From: Michael Eastham
Sent: 14 September 2017 15:41
To: Planning.Responses
Subject: FW: AL/83/17/PL – Mildmay - Hook Lane Demolition of existing dwelling & erection of 1 No. dwelling

Planning application AL/83/17/PL – Mildmay - Hook Lane Demolition of existing dwelling & erection of 1 No. dwelling

REVISION NOTES:		
REV:	DATE:	NOTES:

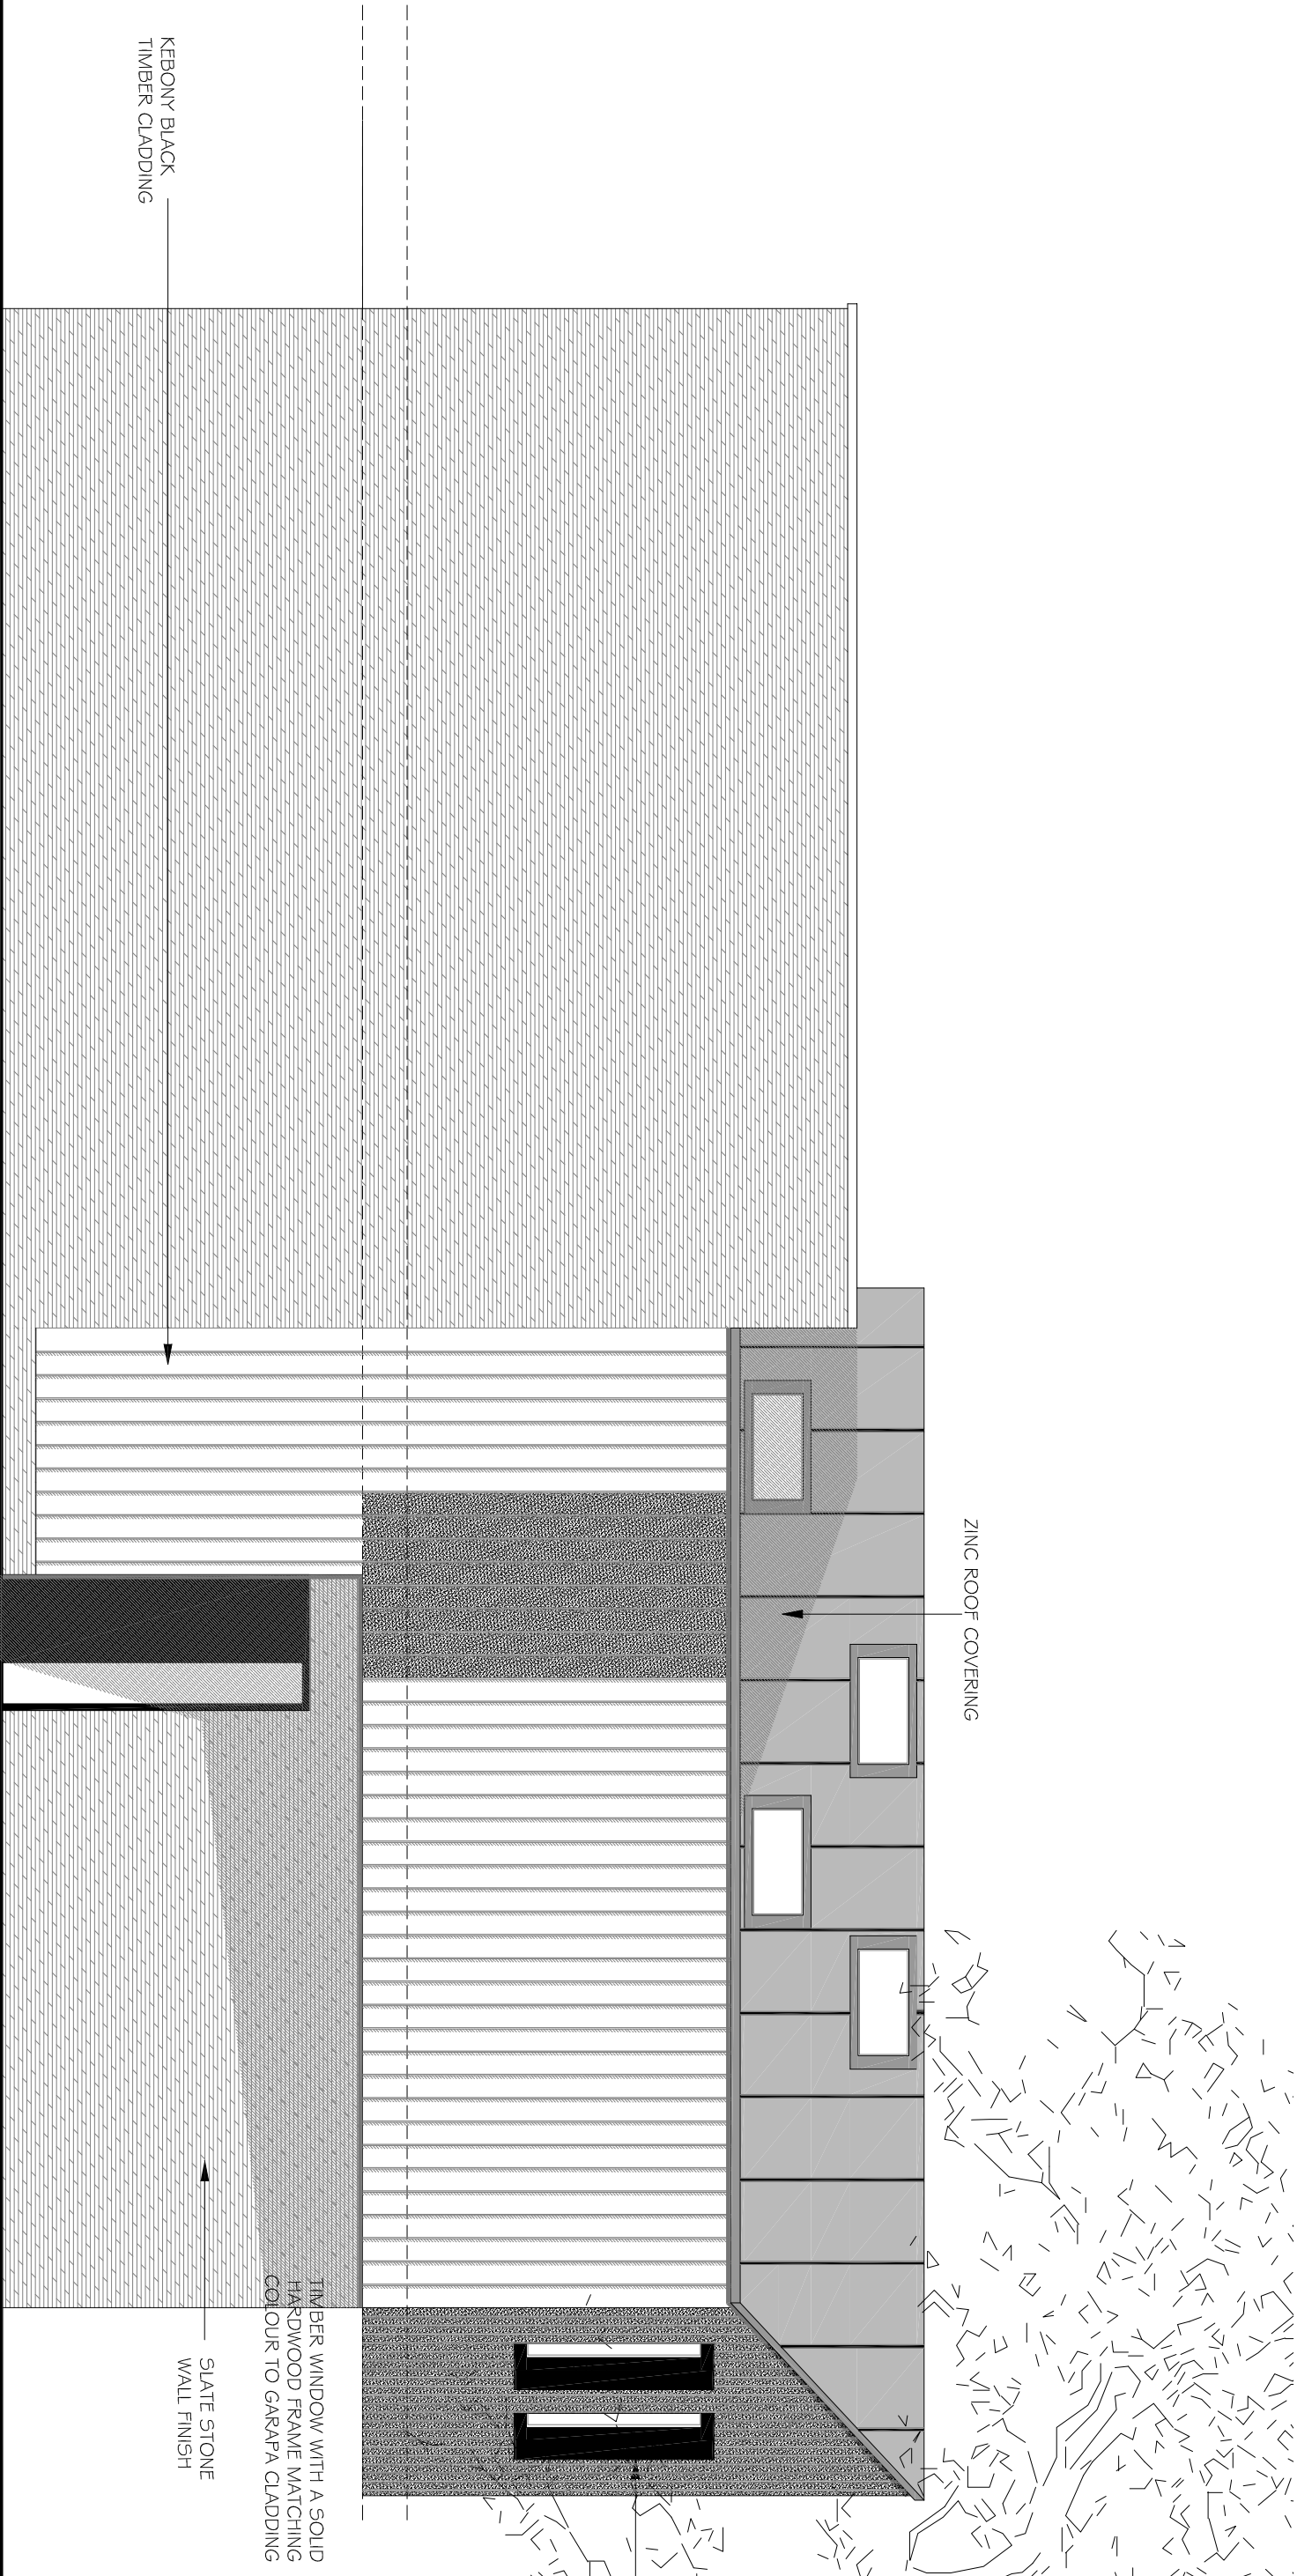
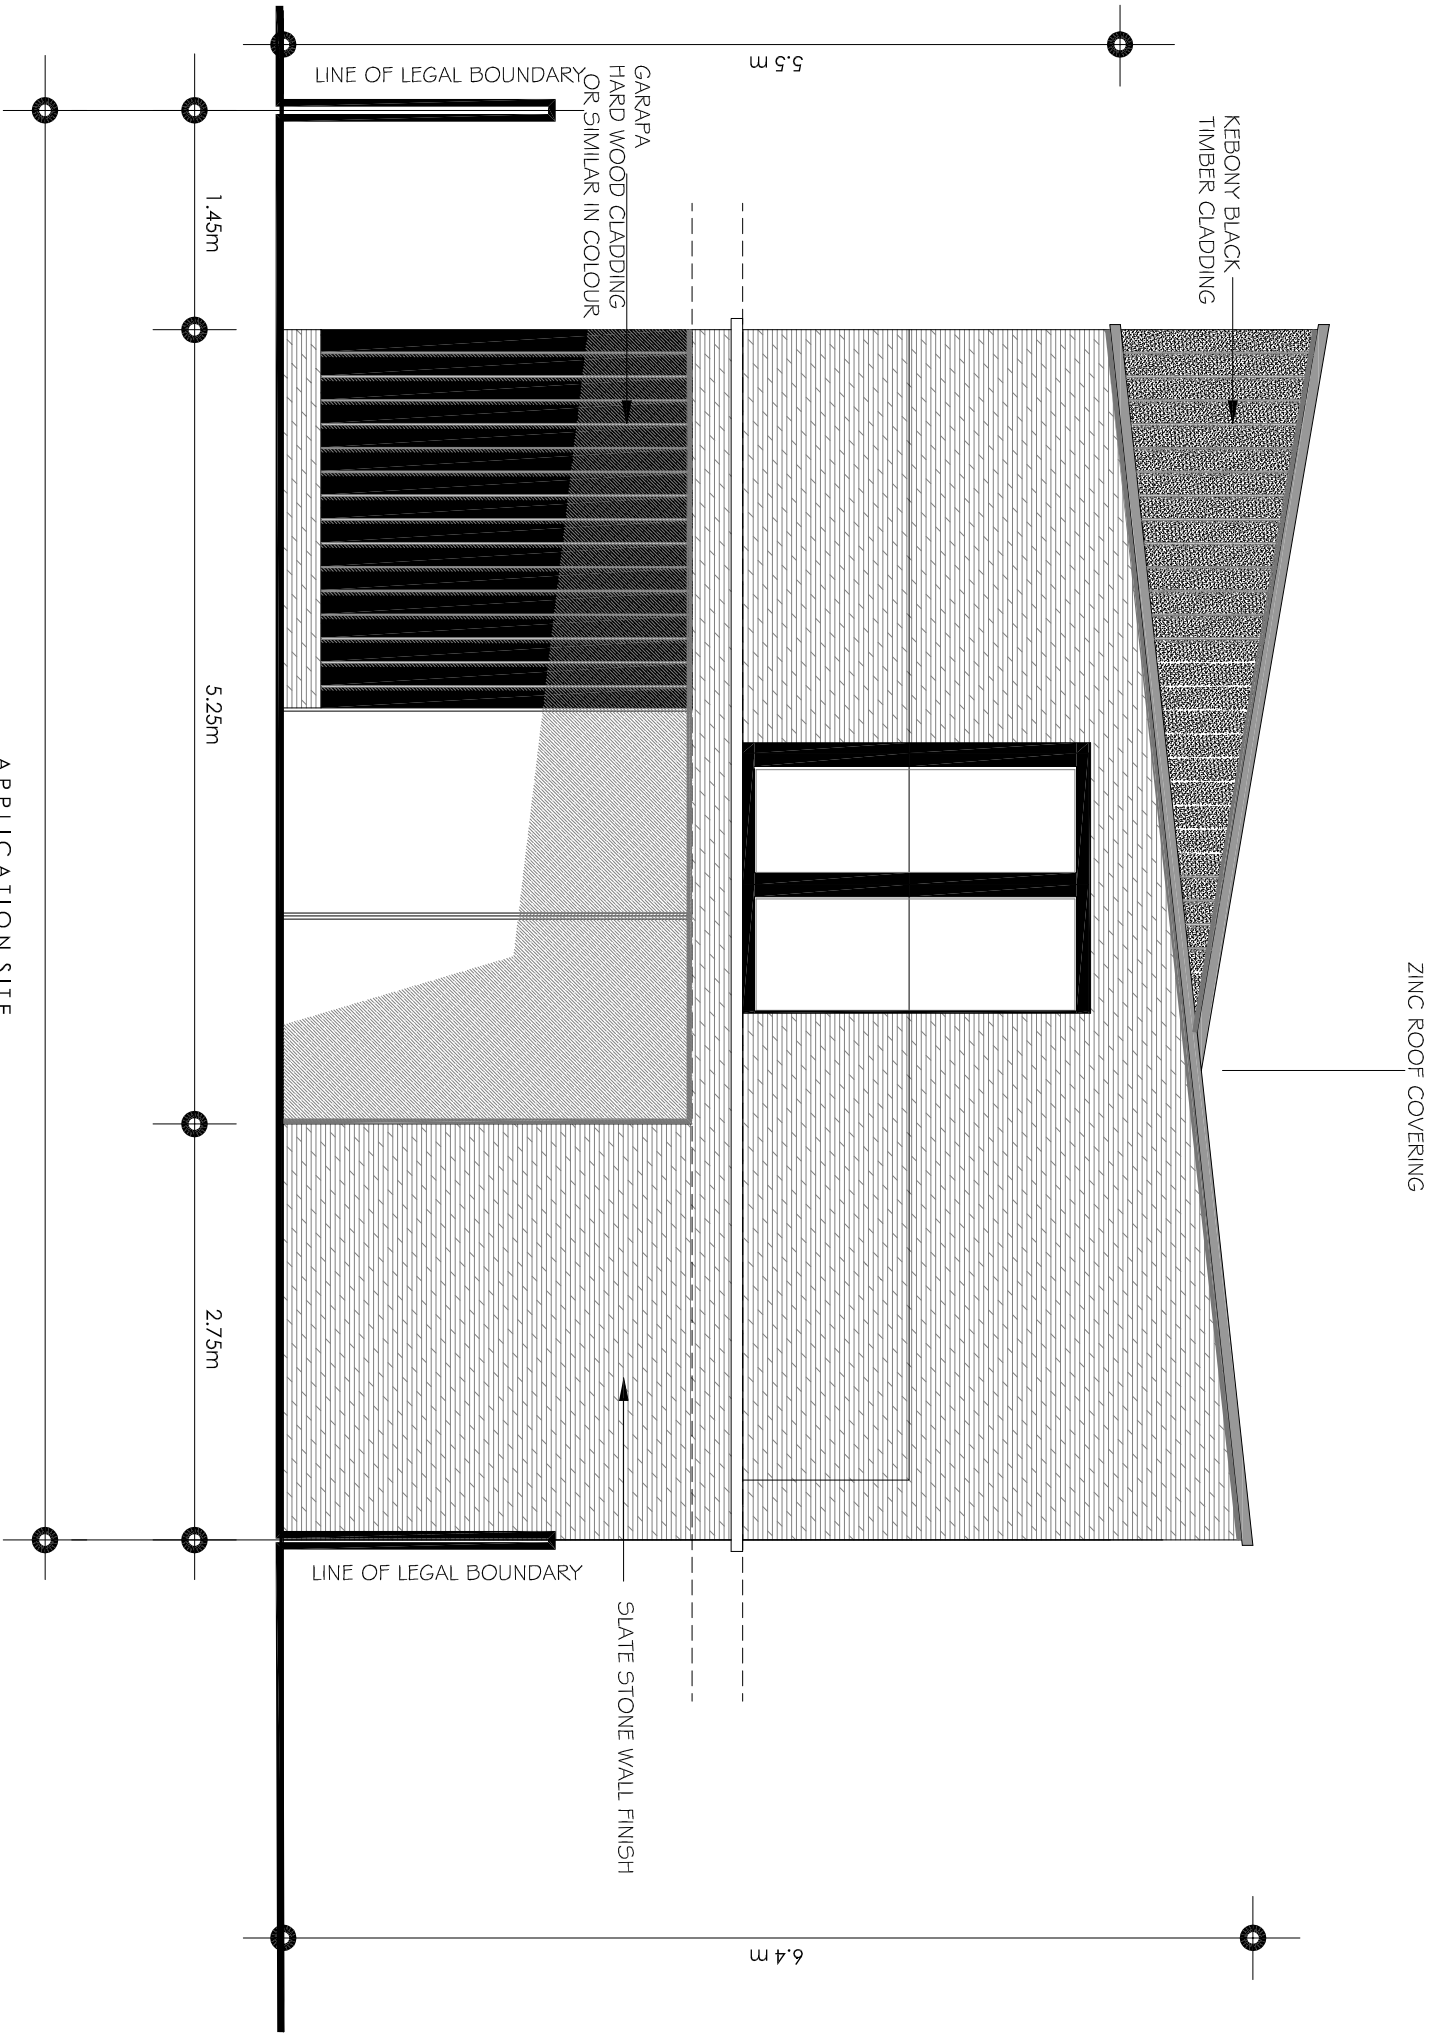
The principle of constructing a replacement dwelling on the site of the unfinished wooden bungalow is acceptable. However, the size, scale, and appearance of the proposed replacement dwelling is completely out of keeping with the character and appearance of the existing houses along Hook Lane and the streetscene.

The proposed dwelling would fit perfectly in a shoreline setting or a woodland setting within Arun District, but it is completely out of keeping with the character of the properties on Hook Lane.

I would be happy to work with you on identifying an alternative house type for the plot of land at Mildmay, but I could not support the current proposed development on the plot.

Looking at the adjacent properties and the stand-off distances, a replacement bungalow would be the ideal solution. The bungalow – or a single storey pavilion style structure - could have a very modern appearance and would probably work really well on the site.
